Our Reference: PA-0004779/01
Customer reference: 3/2026/0238
Date: 05 June 2026

Approval of details reserved by conditions 3 (construction management plan/method statement) 4 (surface water) 5 (bat boxes) 7 (street maintenance) 8 (flood mitigation) 9 (flood management plan) 10 (surface water/foul drainage) 19 (cycle storage) 20 (travel plan) and 21 (operation/maintenance manual) on planning permission 3/2022/1158 granted on appeal APP/T2350/W/25/3368139.

Land South of Accrington Road, Whalley

Environment Agency position

Figure 2 – Flood Compensatory Storage

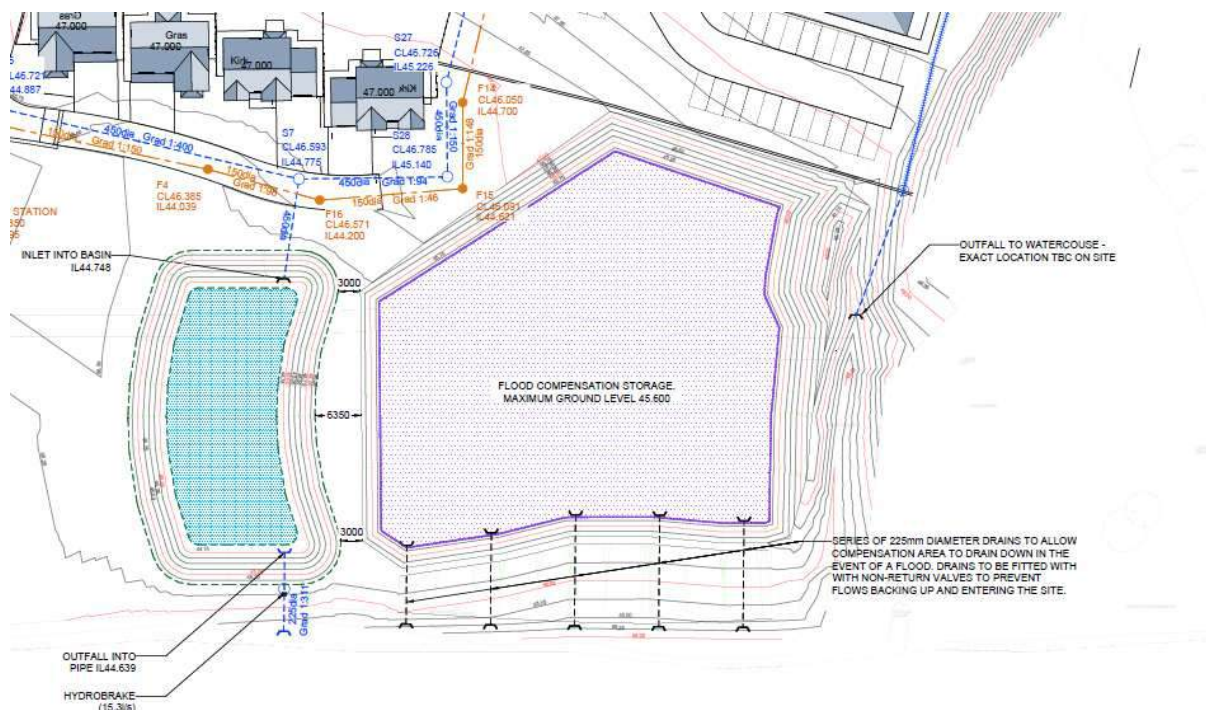
“the plans submitted shall show the final engineering solution for the compensatory storage measures, including (but not limited to) the detailed design and hydraulic modelling to demonstrate how the scheme will function to ensure flood waters can enter the storage and be discharged freely after a flood.”

This requirement has not been demonstrated.

Specifically, the Planning Status plan drawing for the Phase 1 Drainage Layout (Drawing No. 21315-GAD-01-ZZ-DR-C-1001 Rev P06 – Drainage Strategy) has not been updated since October 2023. There is insufficient detail in both plan and section, in relation to the proposed flood compensation area.

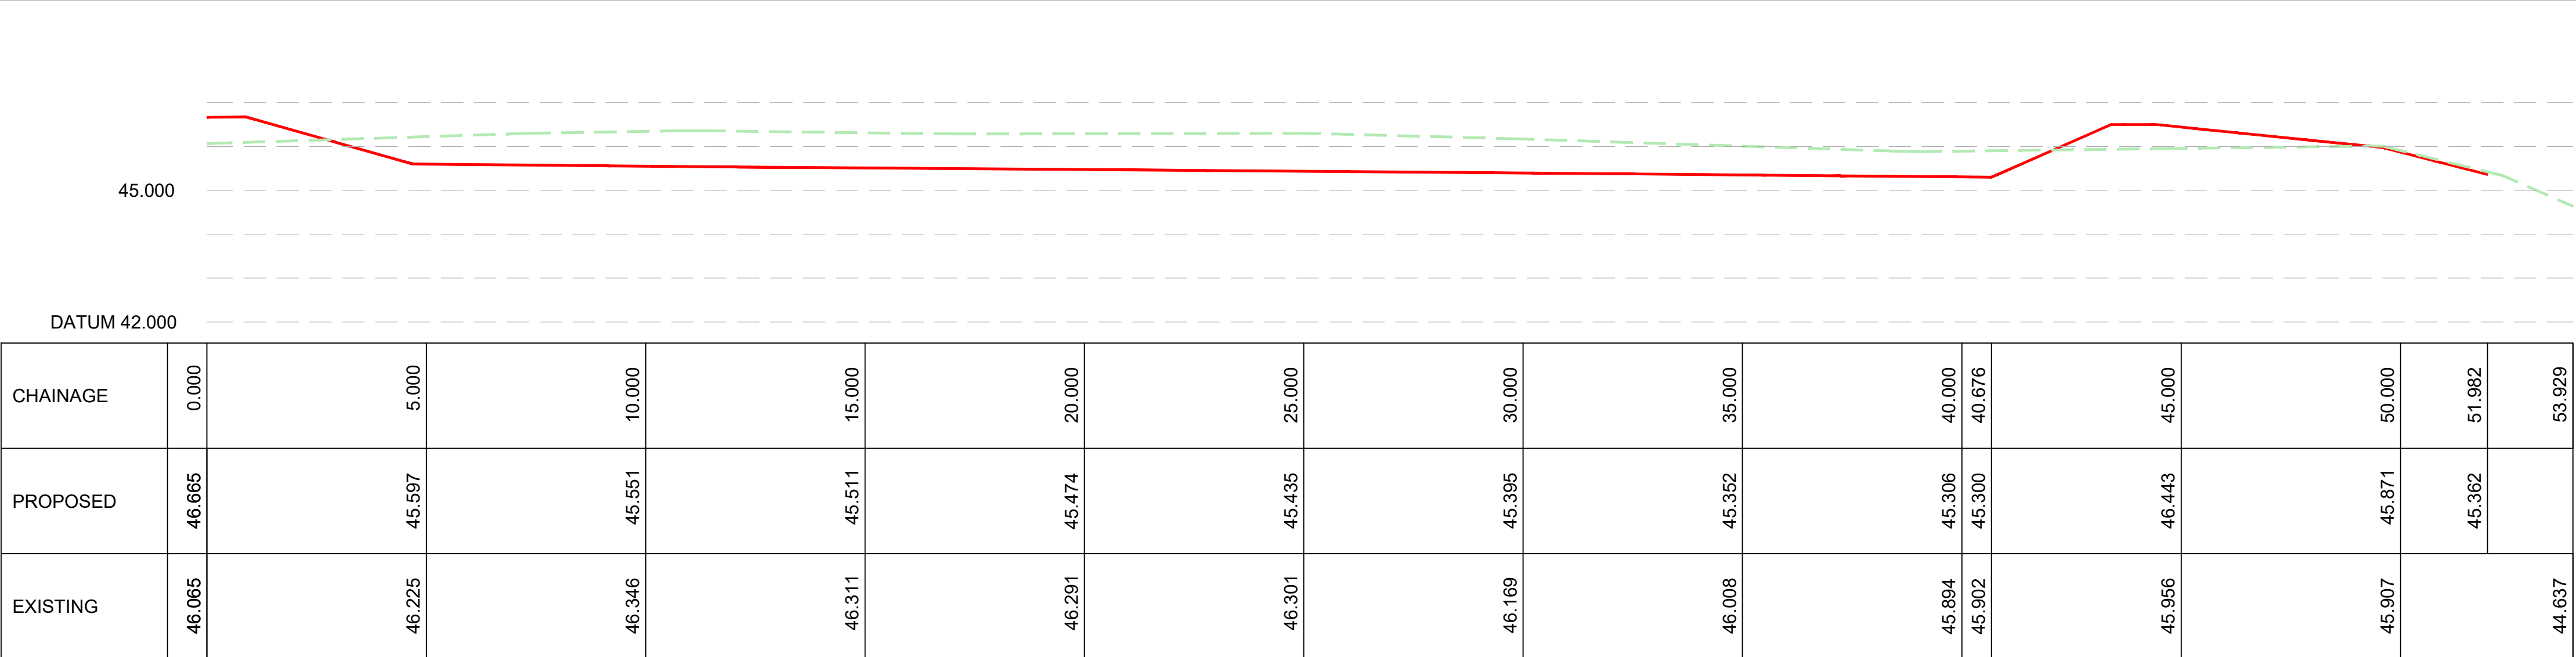
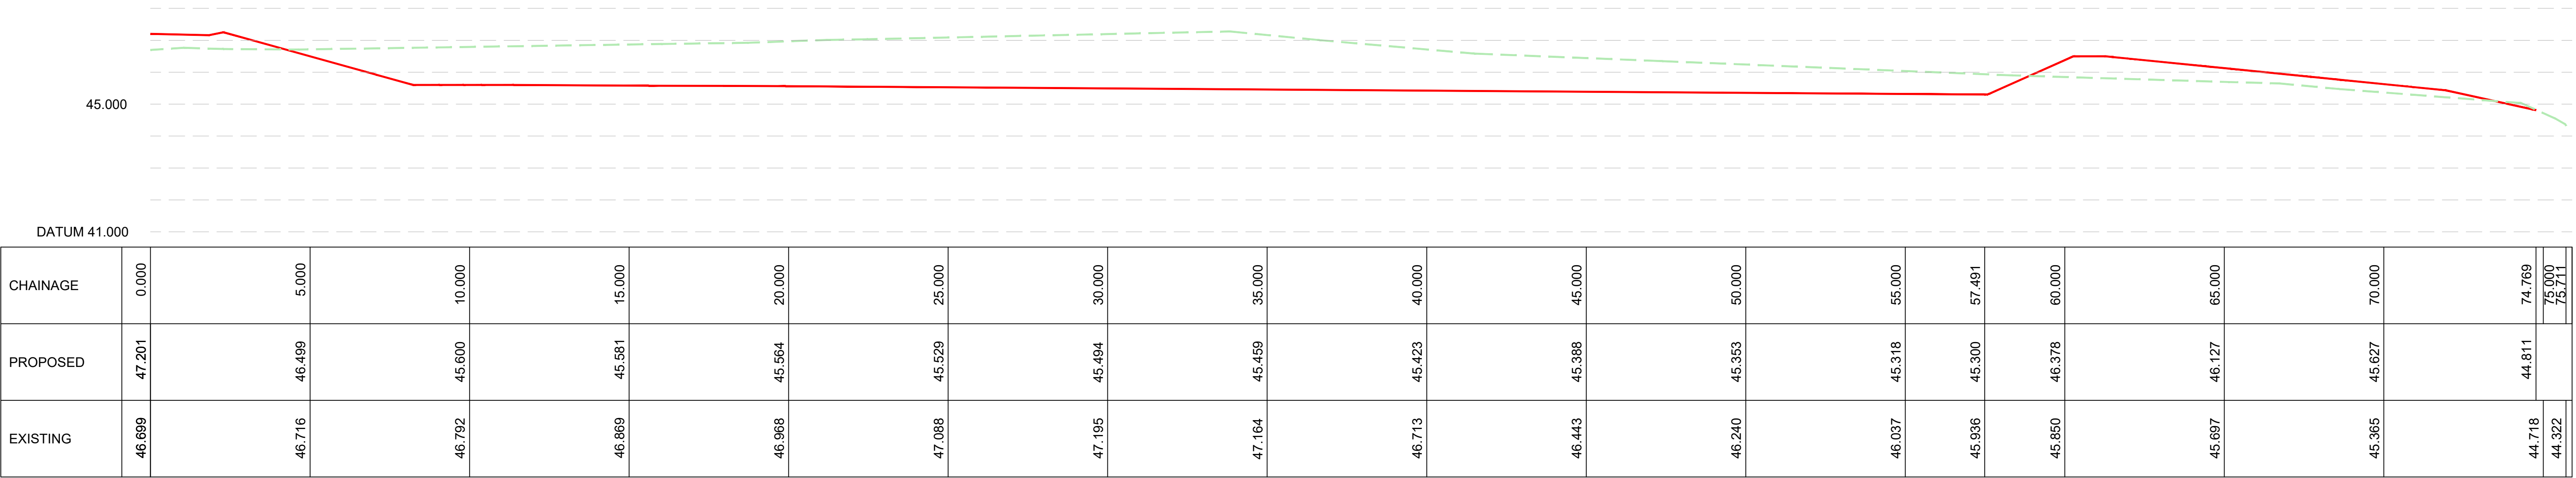
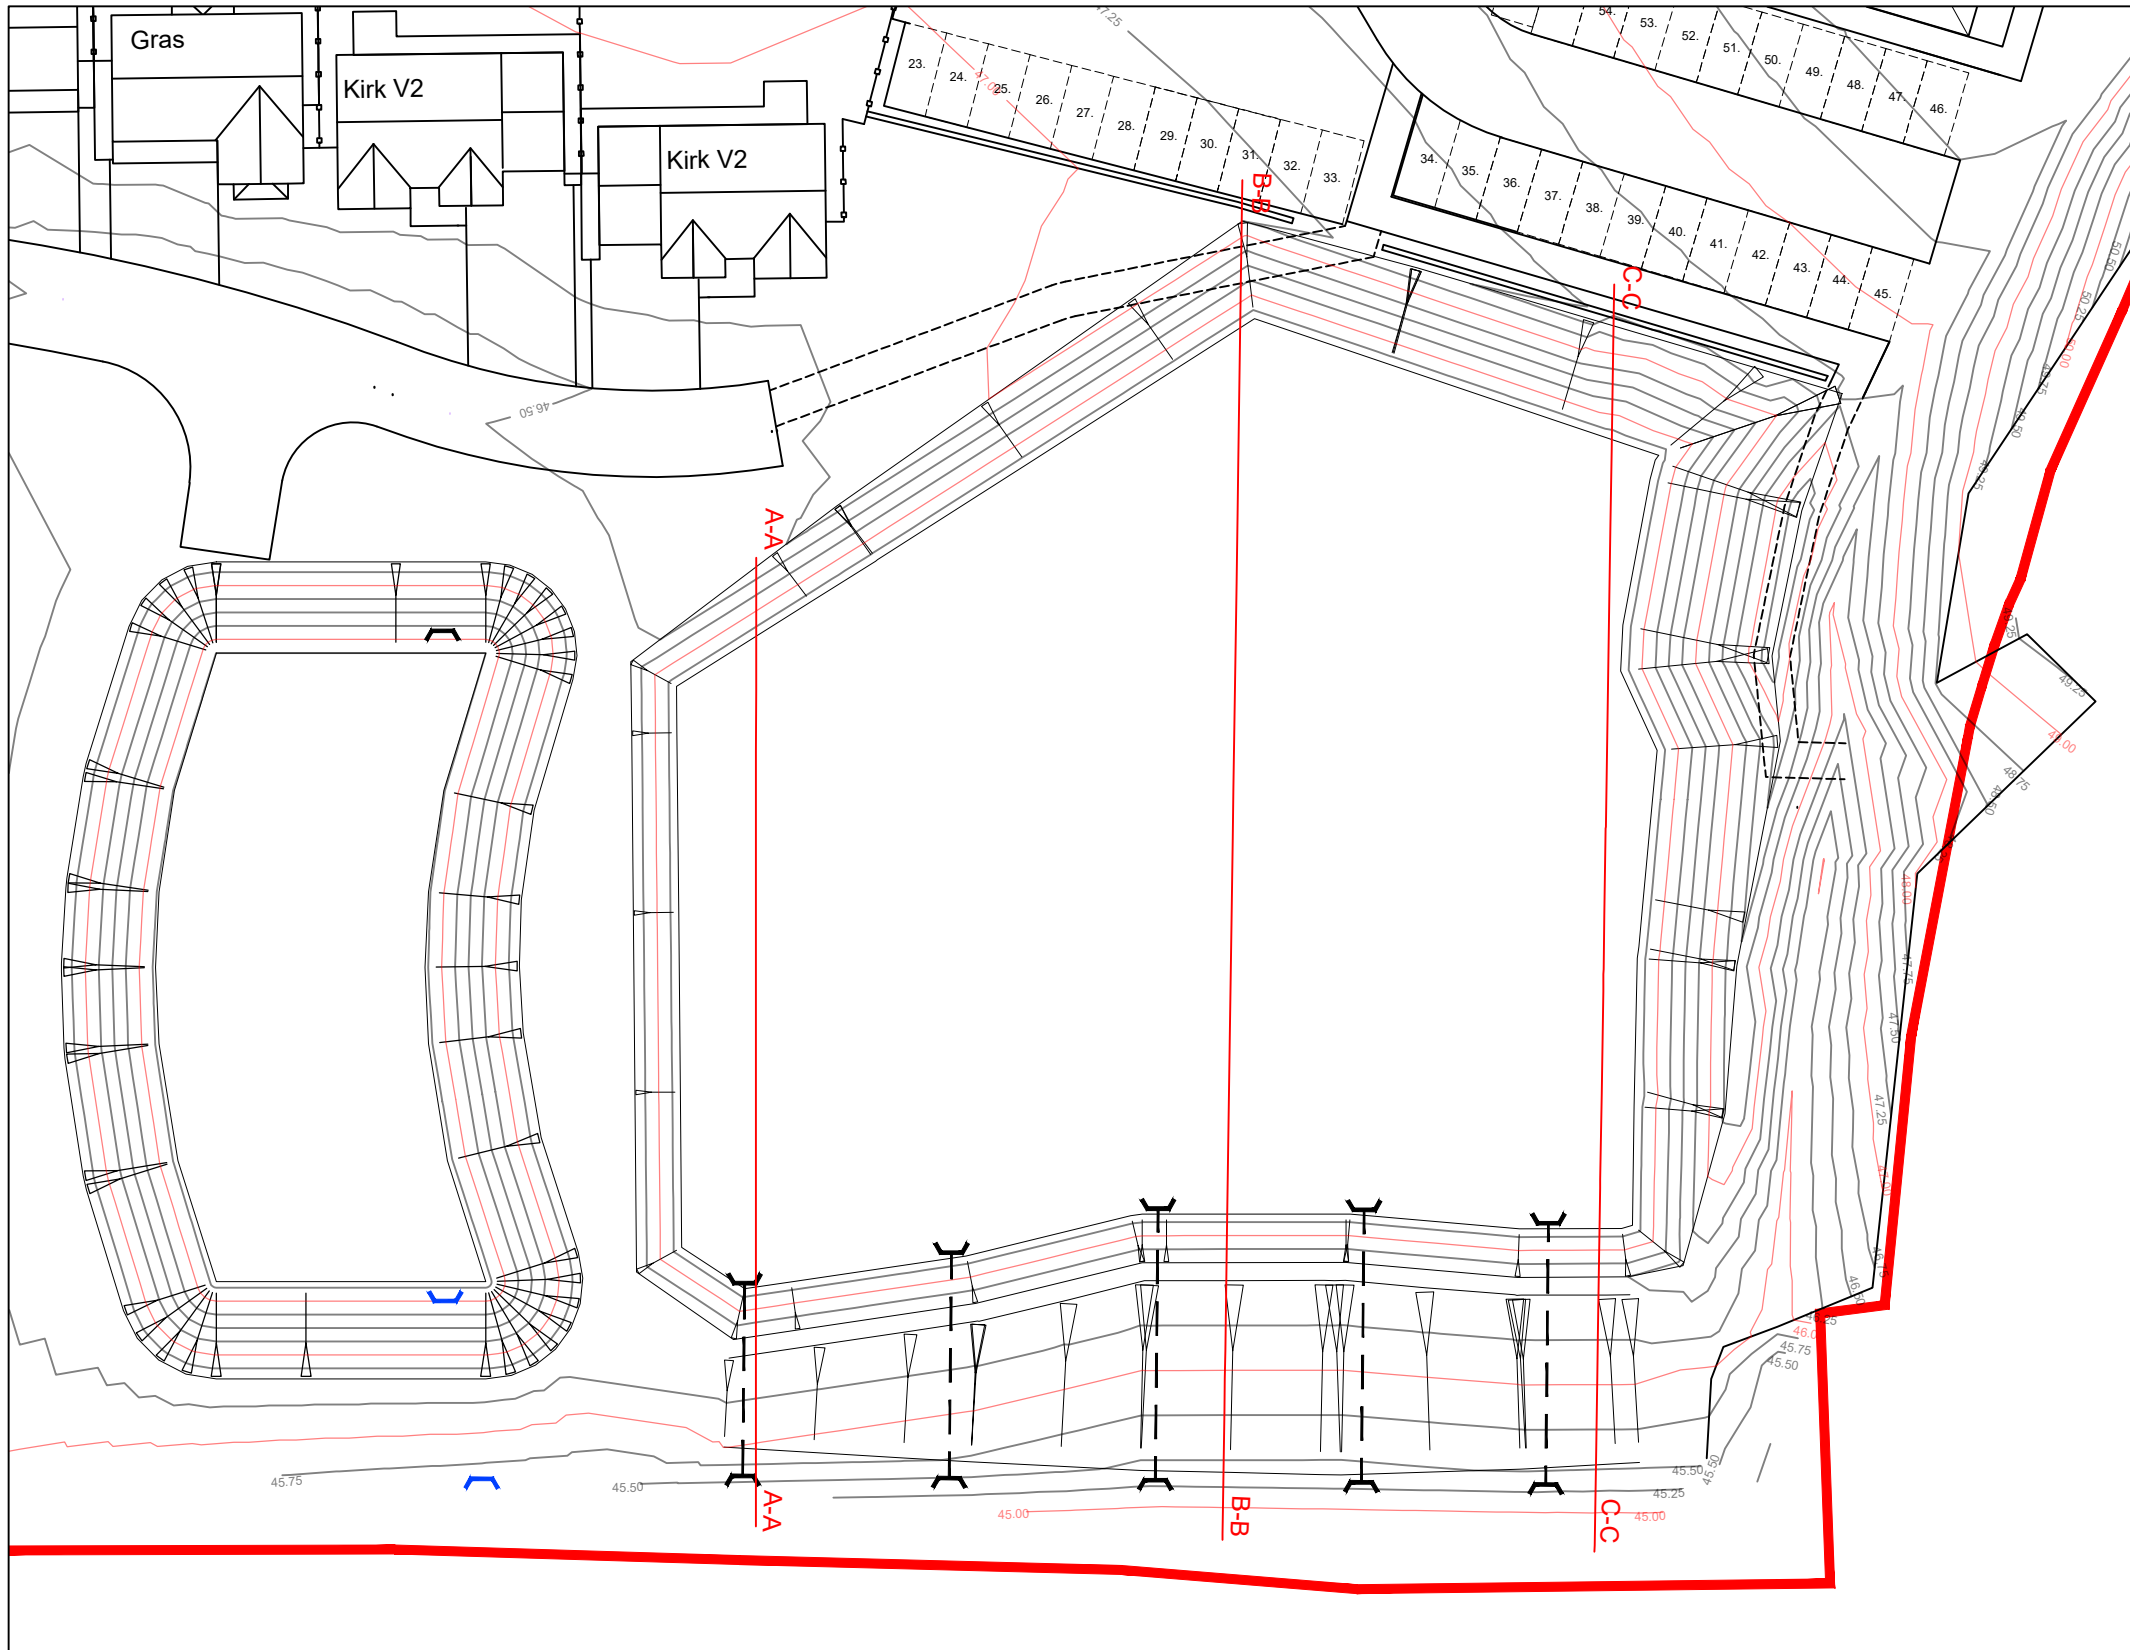
As such, it has not been adequately demonstrated, in engineering terms, how the scheme will function to ensure that flood waters can enter the storage area and be discharged freely following a flood event.
